# CITY OF ALBUQUERQUE

**Re: FedEx Ground ABQ Drainage Report and Grading Plan and Drainage Plan  
Engineer's Stamp Date 8-12-14 (K09D026A)**

Based upon the information provided in your submittal received 8-12-14, the above referenced report and plan cannot be approved for Grading Permit approval nor Building Permit approval until the following comments are addressed:

DRAWN BY
DY
DATE
7-22-14
2013075-GRE
SHEET #
GR-1
JOB #
2013075

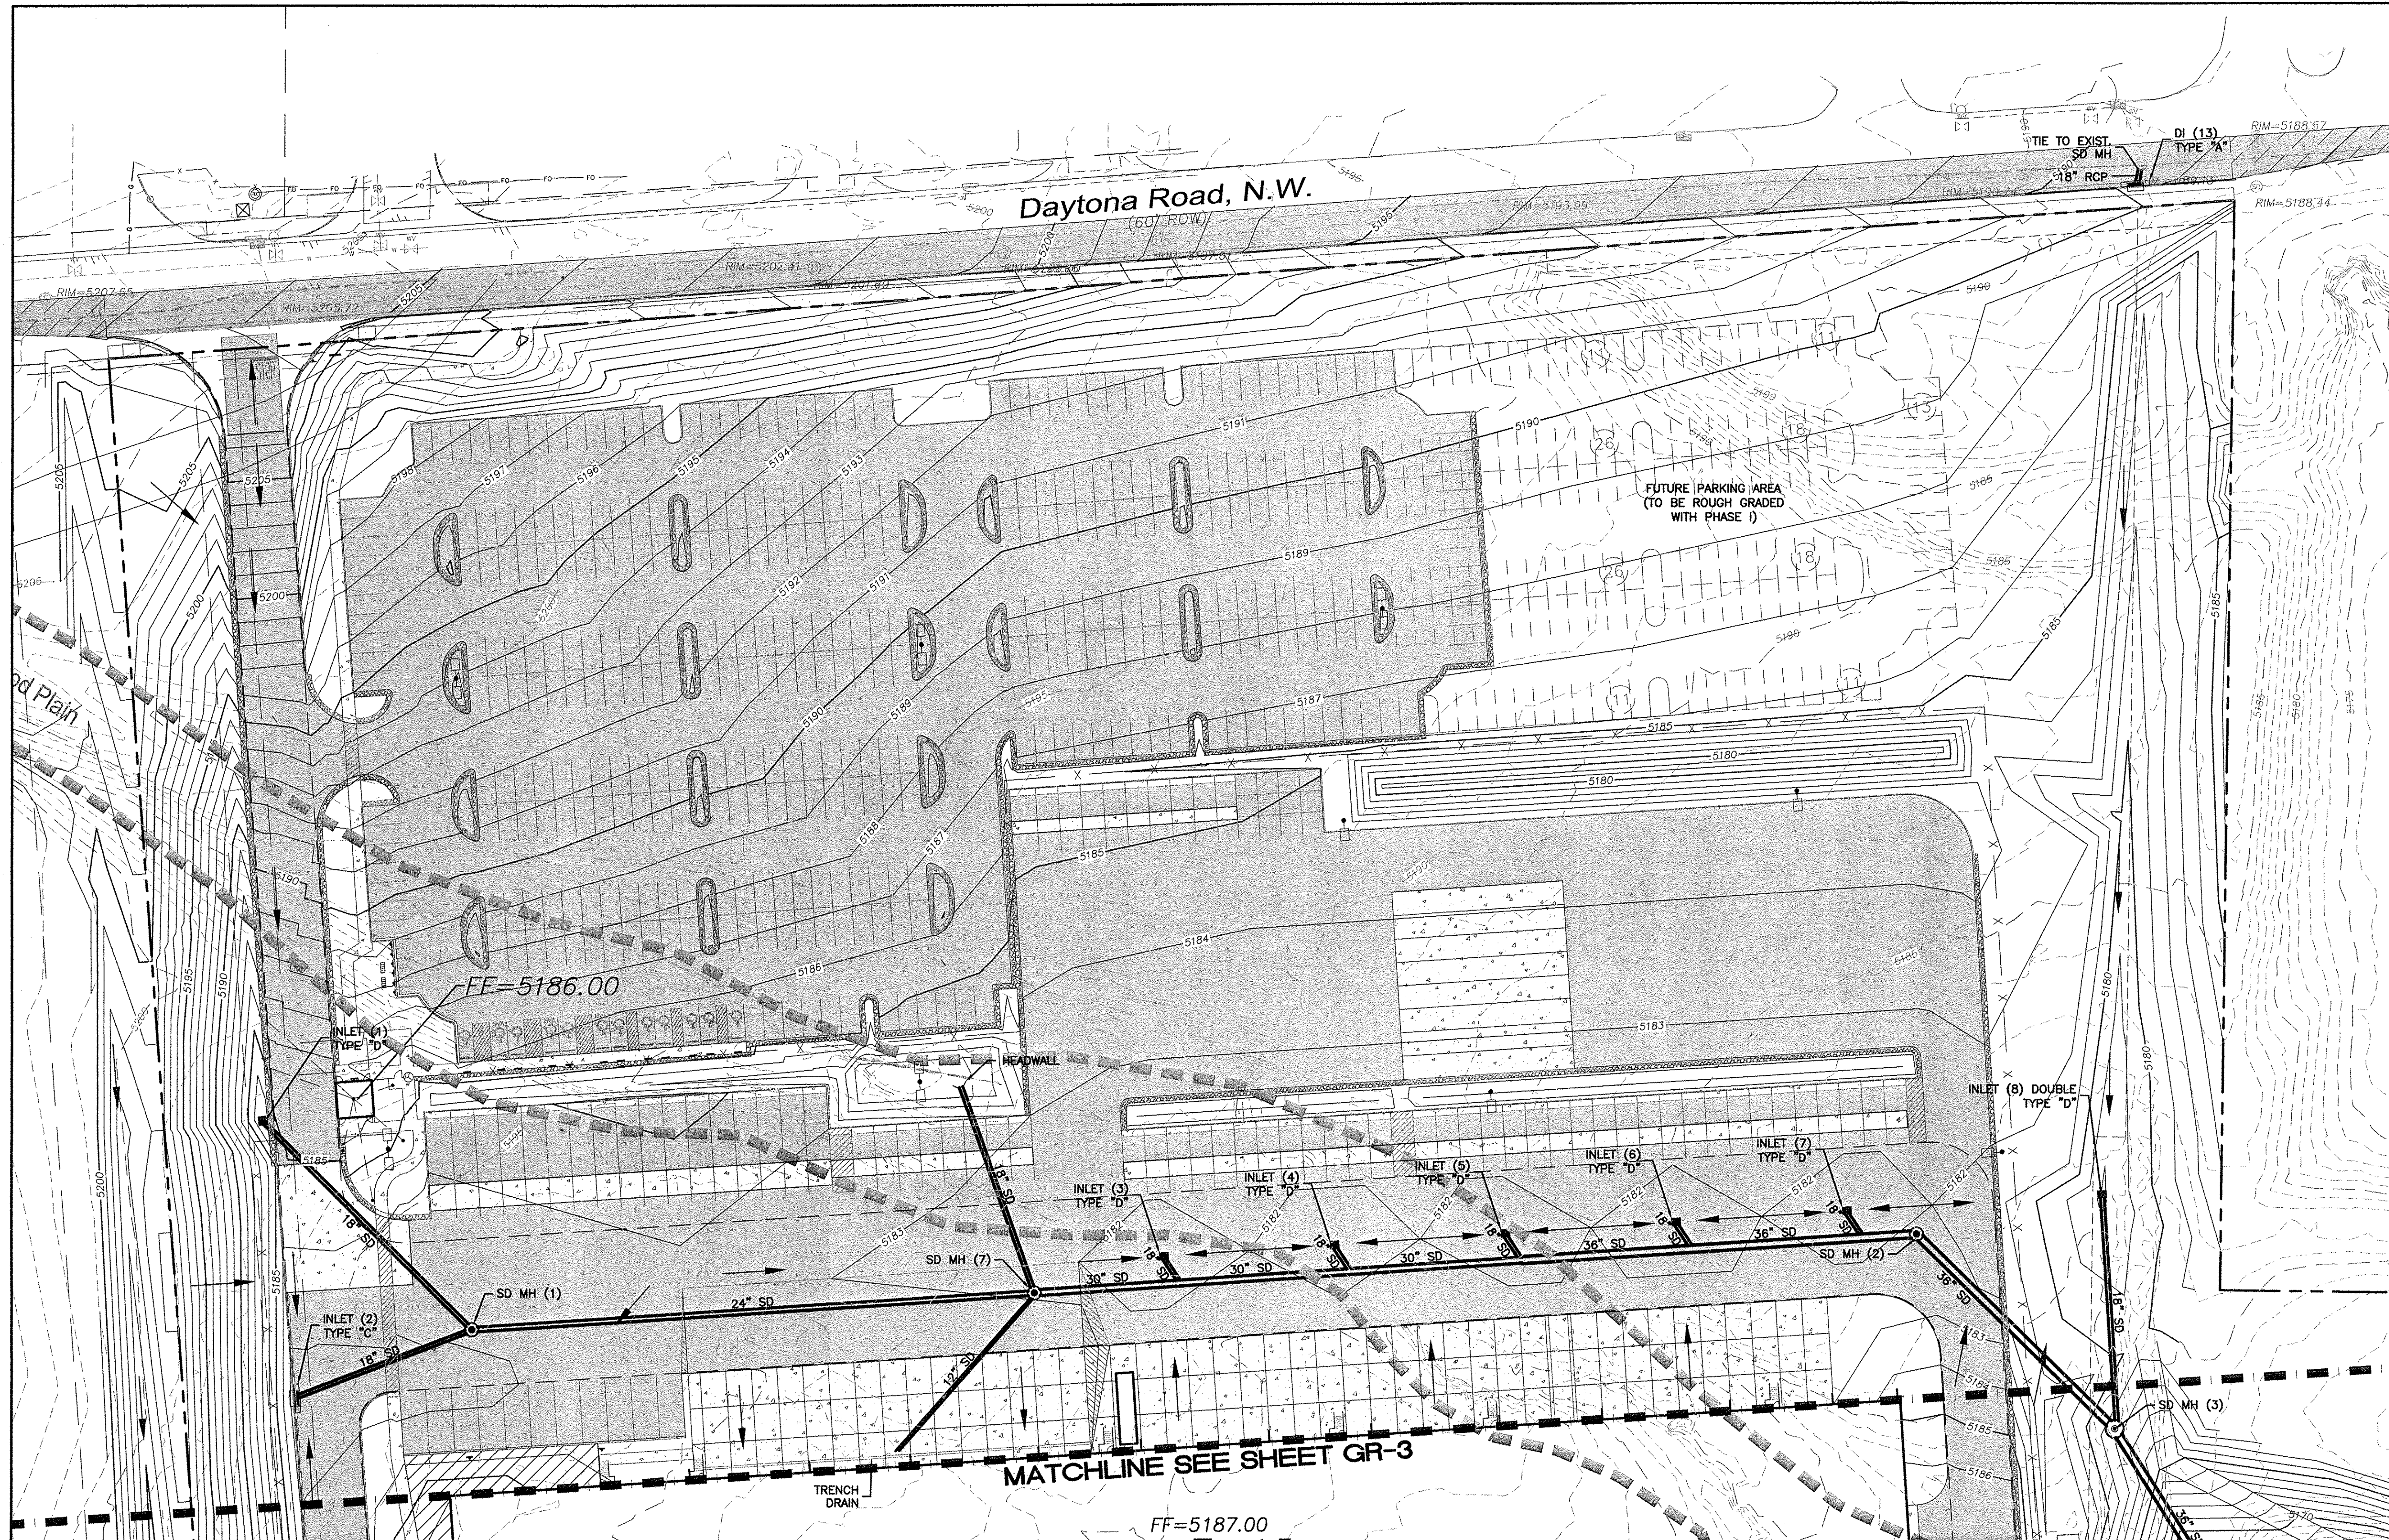
9. Provide headwall details for the four headwalls called out on the plans. What are the inverts of the storm drains going into Pond 5? What is the invert of the storm drain in the small pond north of the proposed building? Include riprap for the design of the desiltation pond north of Los Volcanos since a significant amount of flow will be entering that pond. Have the pond slopes outside the 5 foot PUE.

RONALD R. BOHANNAN P.E. #7868	FEDEX GROUND ALBUQUERQUE, NM	ENGINEER'S SEAL	DRAWN BY DY
			DATE 7-22-14
	GRADING AND DRAINAGE PLAN		2013075-GRE
	TIERRA WEST, LLC 5571 MIDWAY PARK PLACE NE ALBUQUERQUE, NM 87109 (505) 858-3100 www.tierrawestllc.com		SHEET # GR-3
			JOB # 2013075

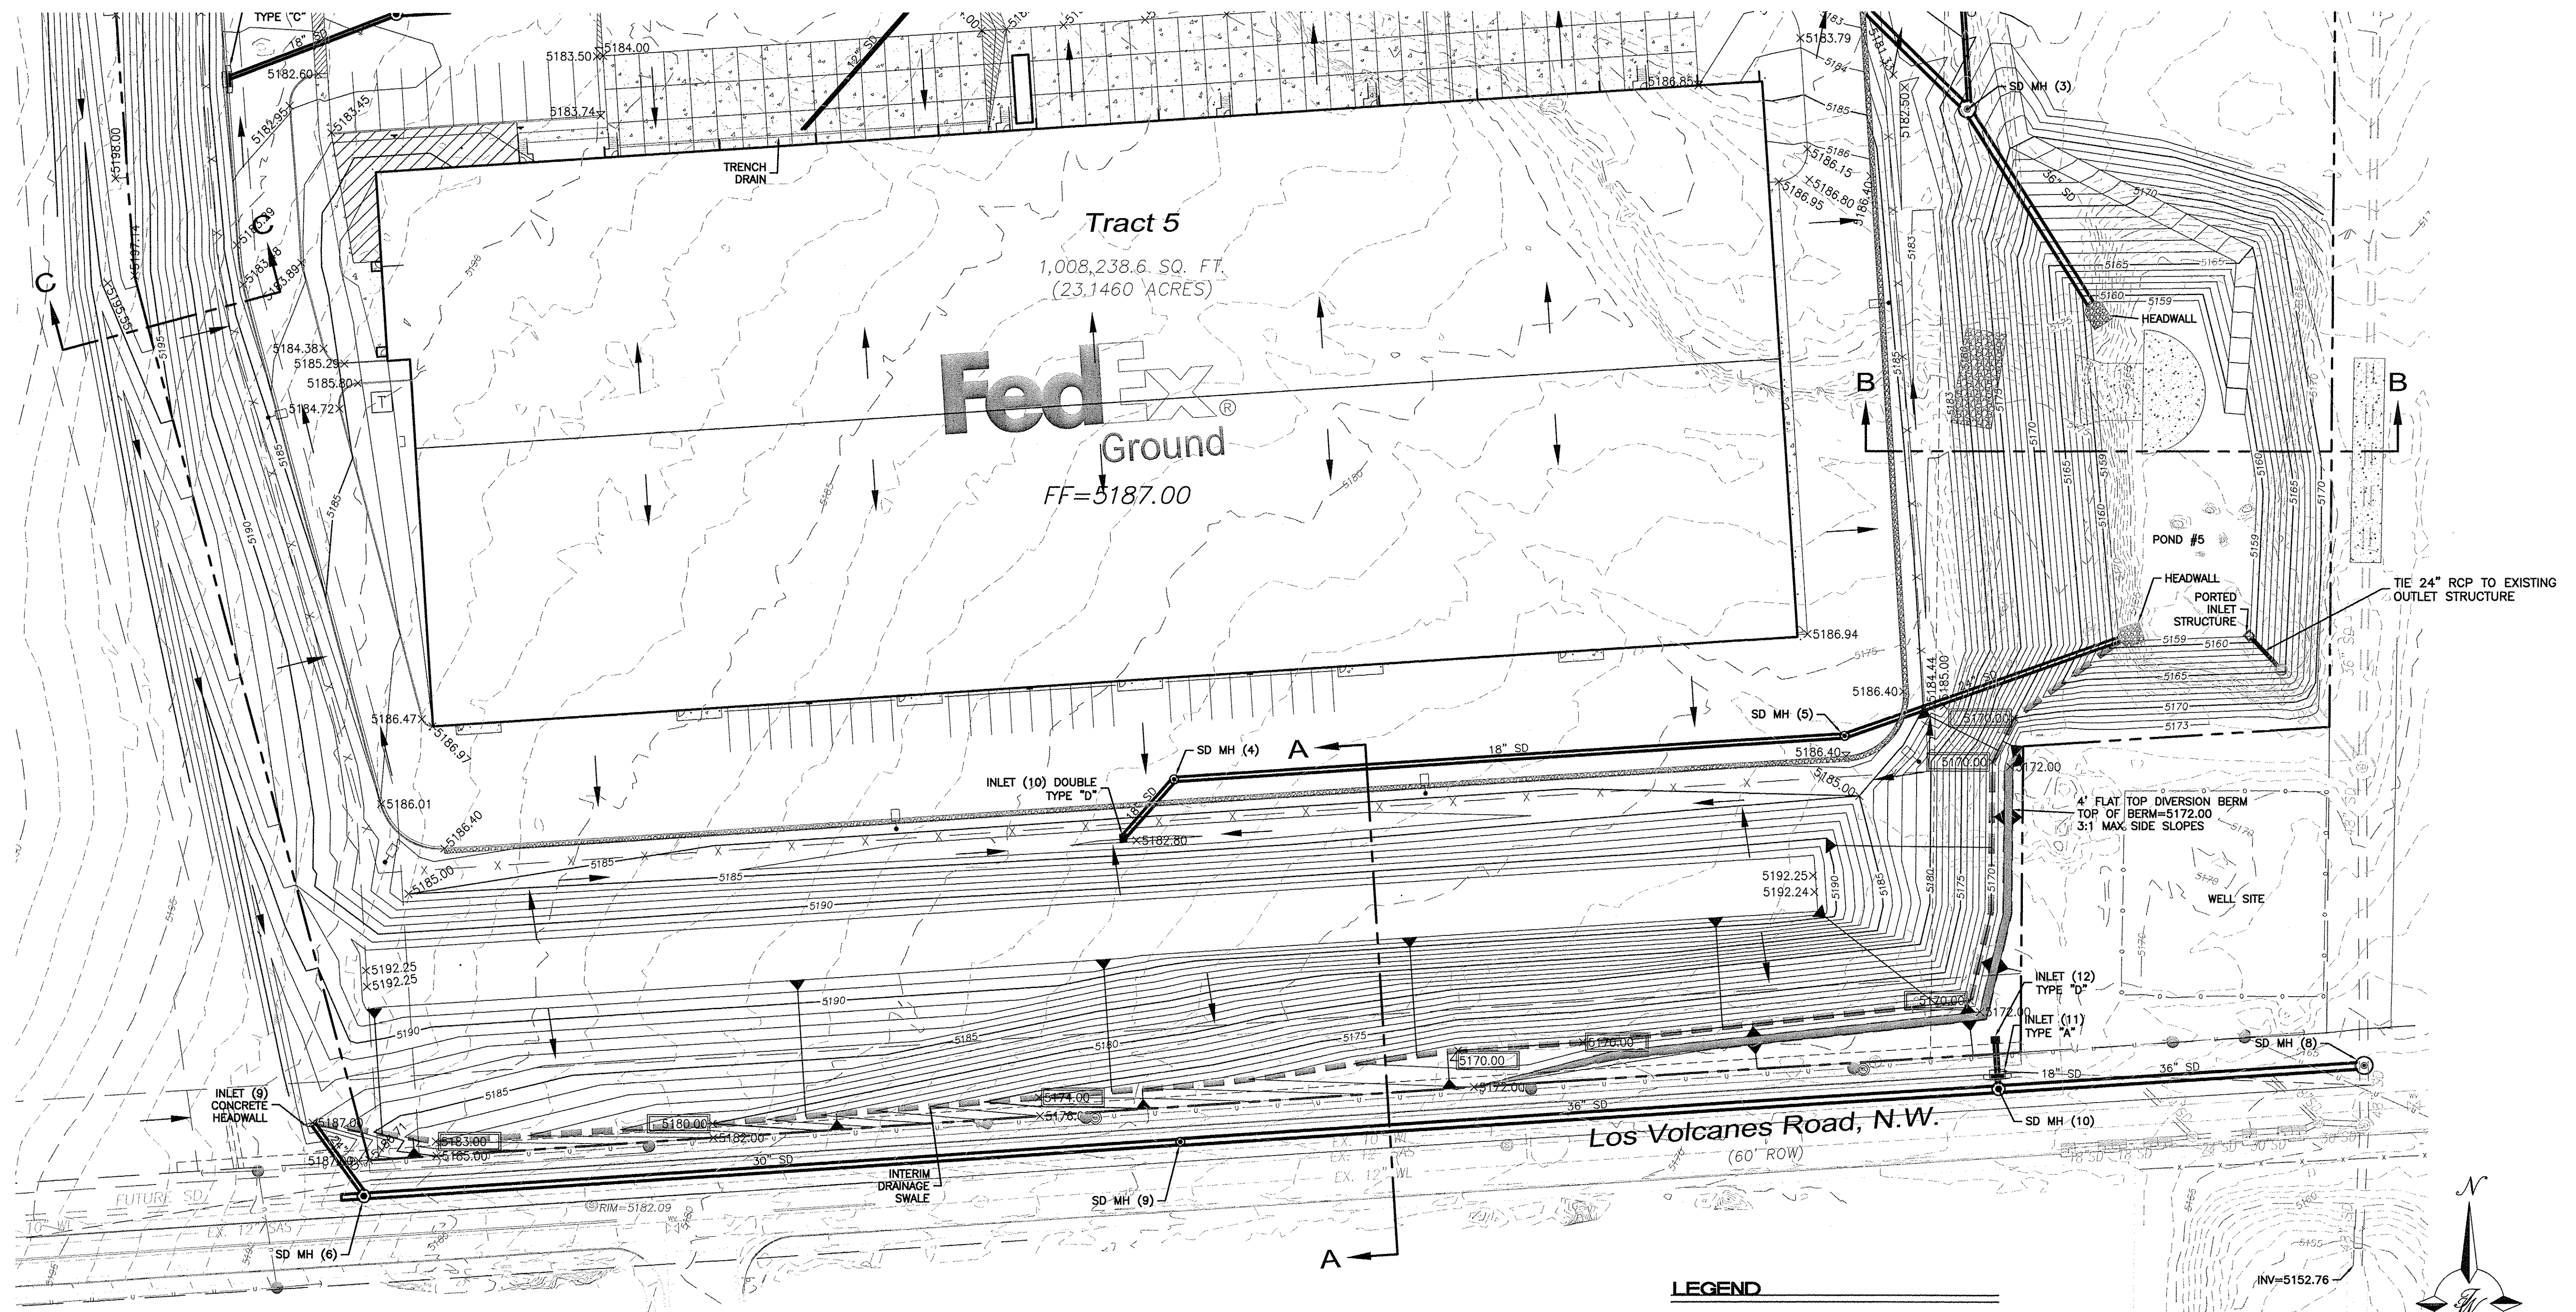
for inlets 11 and 14. Show inlet 14 on the Post Developed Drainage Basin Map. On GR-3, show what storm drains will be abandoned with CPN 655784.

ENGINEER'S SEAL RONALD R. BOHANNAN P.E. #7868	FEDEX GROUND ALBUQUERQUE, NM		DRAWN BY DY
	INTERIM GRADING AND DRAINAGE PLAN		DATE 7-22-14
	TIERRA WEST, LLC 5571 MIDWAY PARK PLACE NE ALBUQUERQUE, NM 87109 (505) 858-3100 www.tierrawestllc.com		2013075-GRE-INTERIM
	SHEET # GR-4		JOB # 2013075

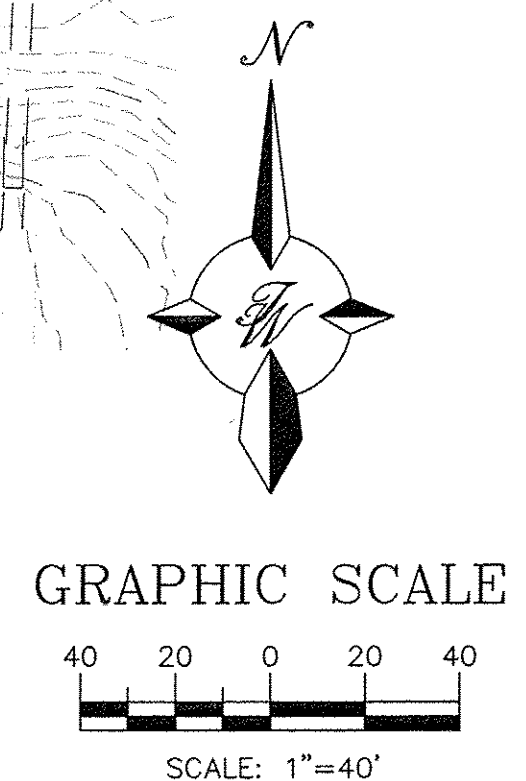
11. An Interim Grading and Drainage Plan dated May 19, 2014 was approved for grading permit. A revised Interim Grading and Drainage Plan was submitted with the last submittal. Since you have already received approval of it for the grading permit, remove the Interim Grading and Drainage Plan from the next submittal.

POND 5 OUTLET STRUCTURE MODIFICATION DETAIL
NTS

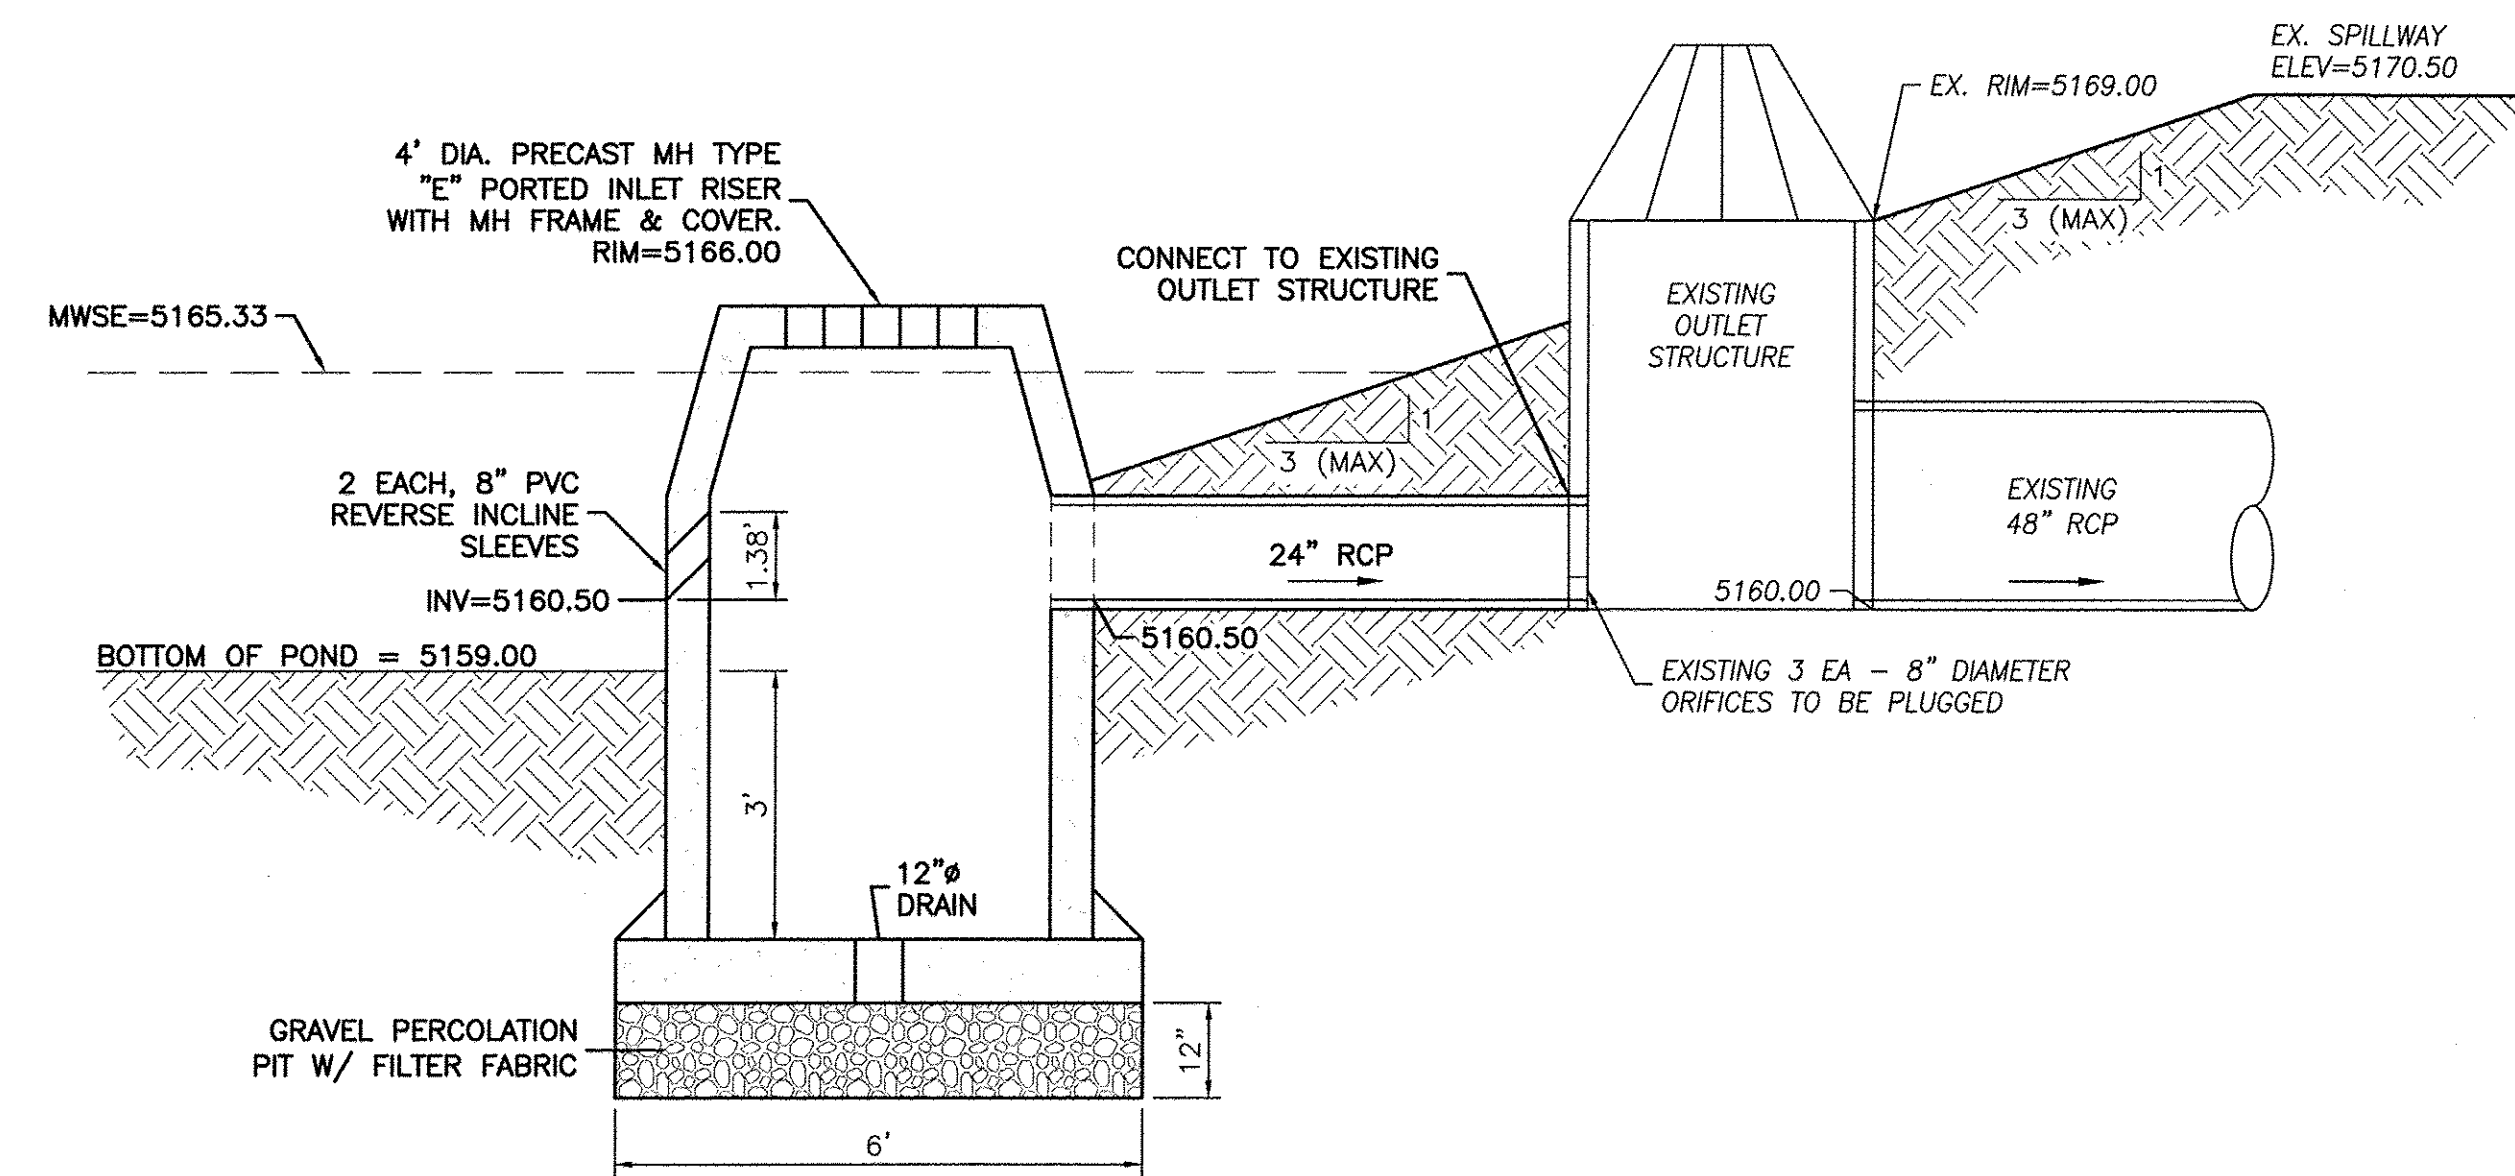
10. On GR-5, what is the invert of the 24 inch entering the existing outlet structure? What is the length of the 24 inch storm drain? Show one foot of cover minimum over the 24 inch storm drain. Instead of plugging the existing 3 orifices in the existing outlet structure, provide an opening for the new 24 inch pipe.
